Our Ref: 150325_EN020019_3087770

Date: 25 March 2015

Planning Inspectorate comments on the draft Triton Knoll Electrical System (TKES) Report to Inform Appropriate Assessment (RIAA)

TITLE: Figure 4-6  
Export Cable Route Options for ISA

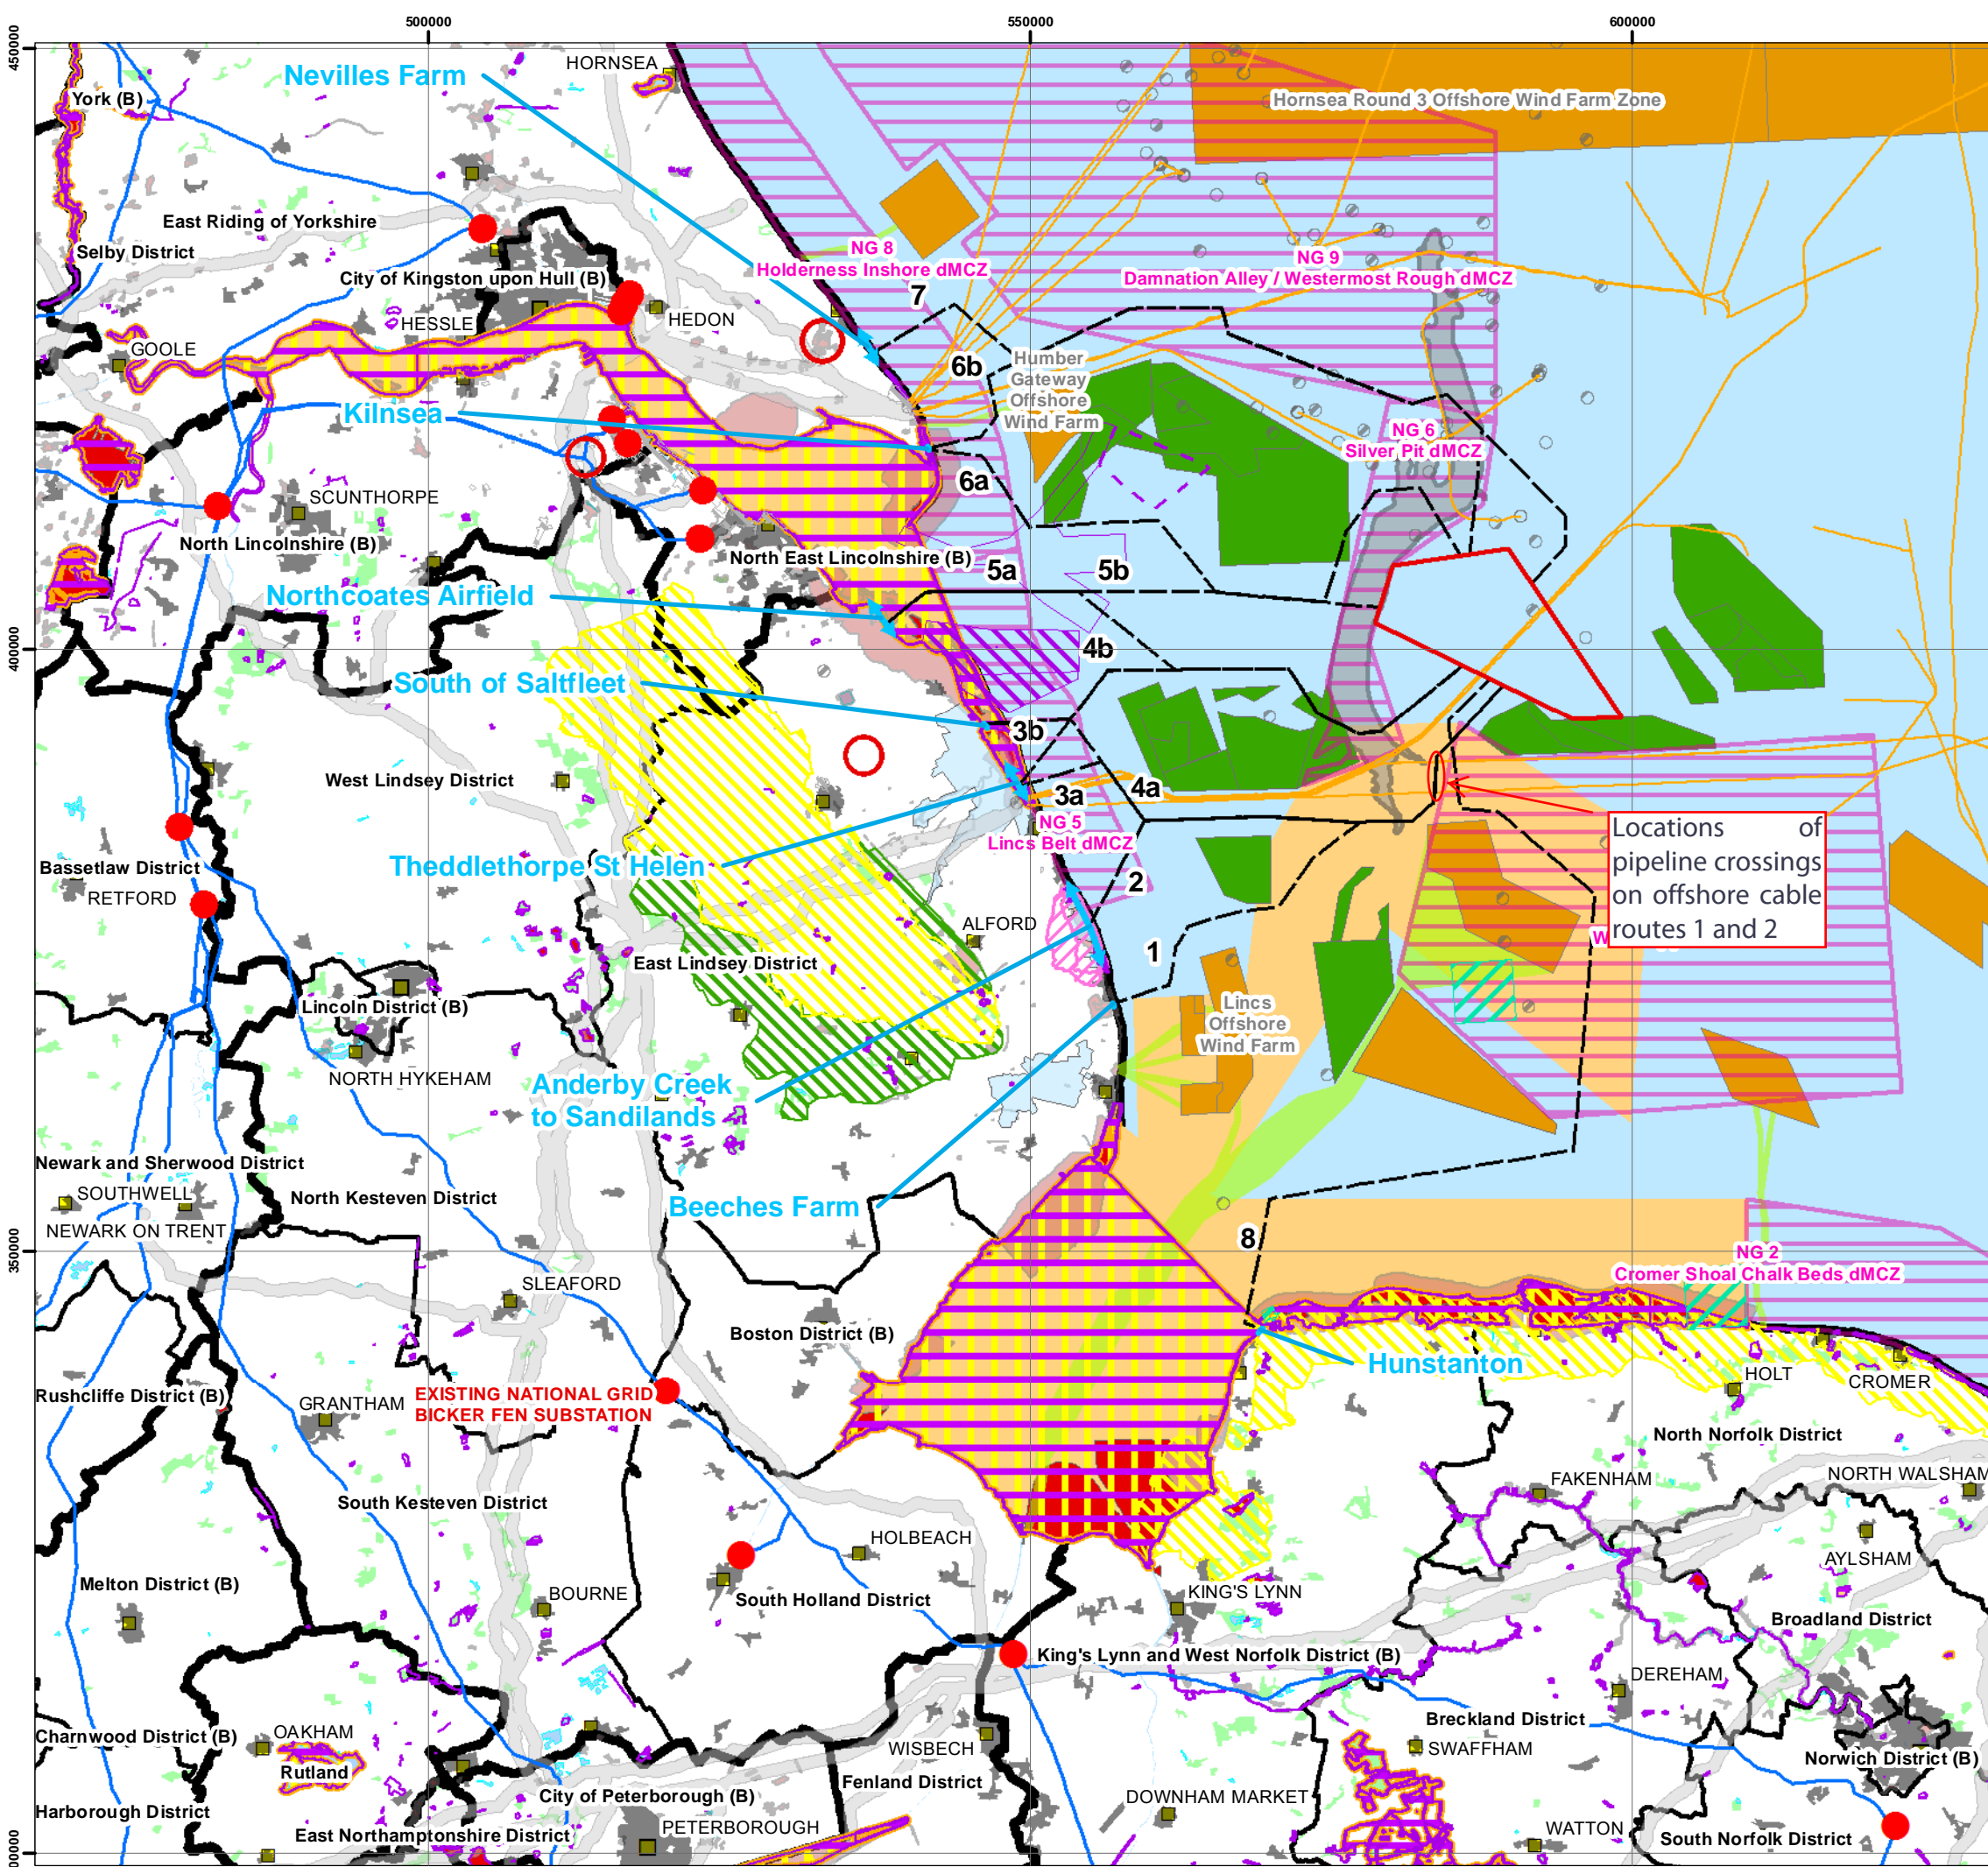
- (ii) It would be useful if the required pipeline crossings were identified on a figure within the RIAA.
 - (iii) The cable protection area of 30,000km² does not match the figure provided in the DML Condition 2 and this should be explained.
